TfNSW Reference: SYD20/00598/03

Client Reference: SSD 10465

**EXHIBITION OF EIS FOR REDEVELOPMENT OF MOSMAN HIGH SCHOOL TO
INCREASE STUDENT NUMBERS - 769 MILITARY ROAD, MOSMAN (SSD 10465)**

Figure 9 - 1-seat trip bus routes within school catchment area

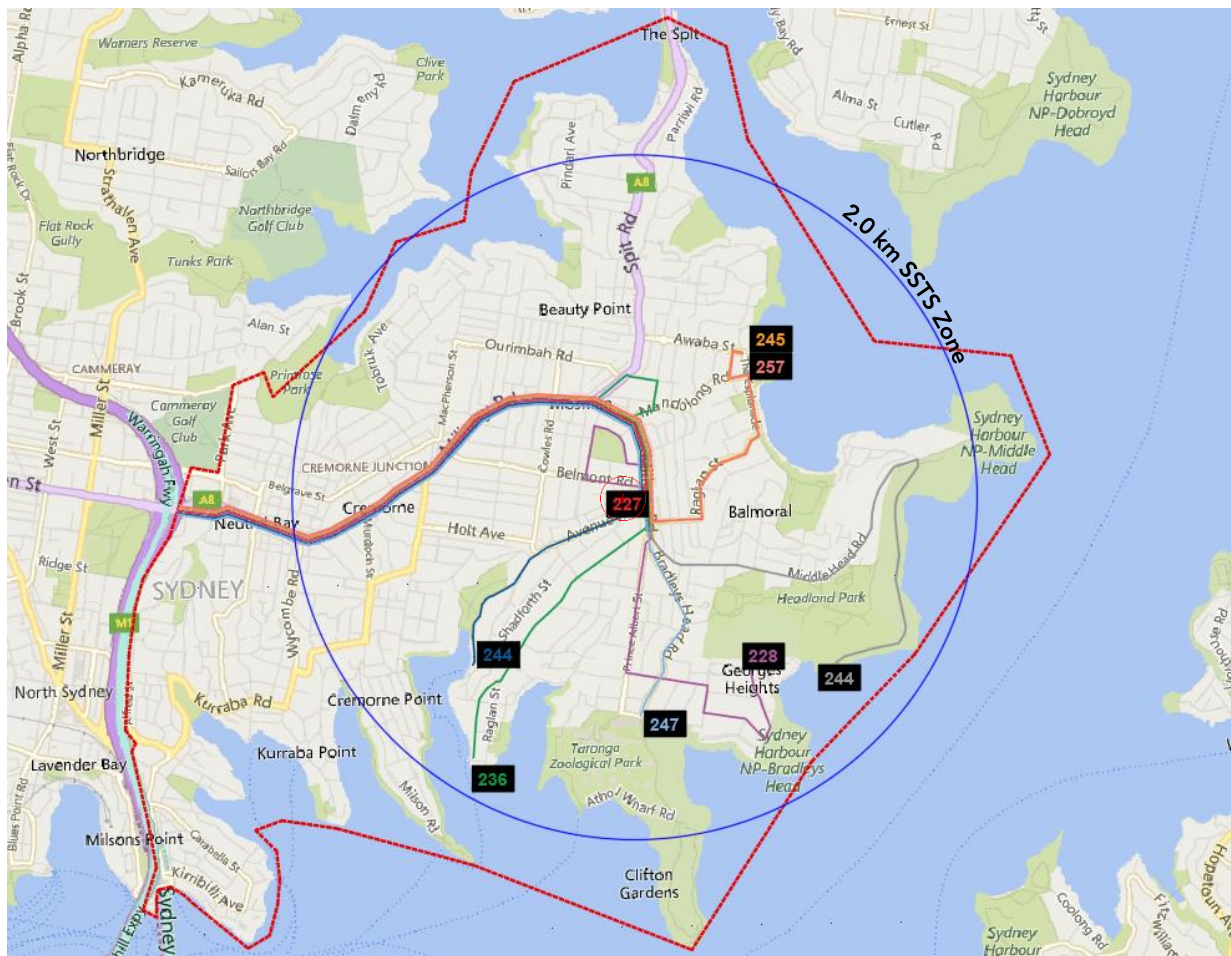
- Figure 8 shows an outdated network map;
- On page 21 (document page 17) of the routes listed in the 1st paragraph, only the 228 is still operating and the previous route 230 (missing), is also still operating;
- Figure 9 is no longer current. The route shown on Avenue Rd as the 244 is the 230;
- Table 1 - Summary of Bus Services needs to be updated, as most of the routes no longer exist; and
- Figure 10 – Summary of School Bus Services, the 575n no longer operates and is

The TIA and GTP need to be updated to reflect accurate public transport information. The most current Bus Network Maps may be found at: <https://transportnsw.info/travel-info/ways-to-get-around/bus/bus-operator-maps>

Figure 11 - 1-seat trip school bus routes within school catchment area

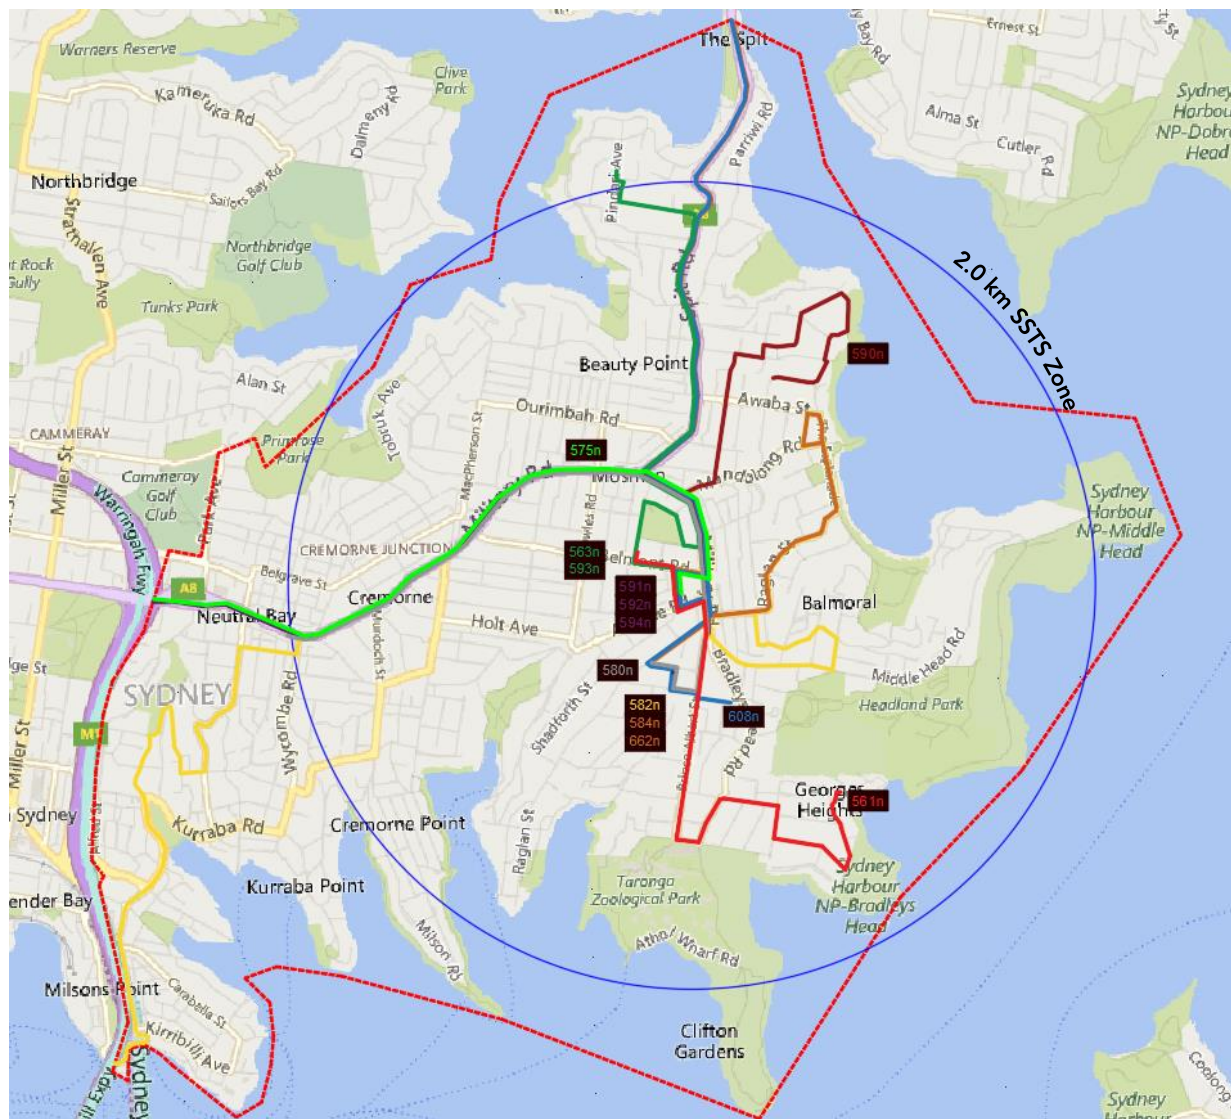
replaced by additional frequency on 100, 114 and 230.
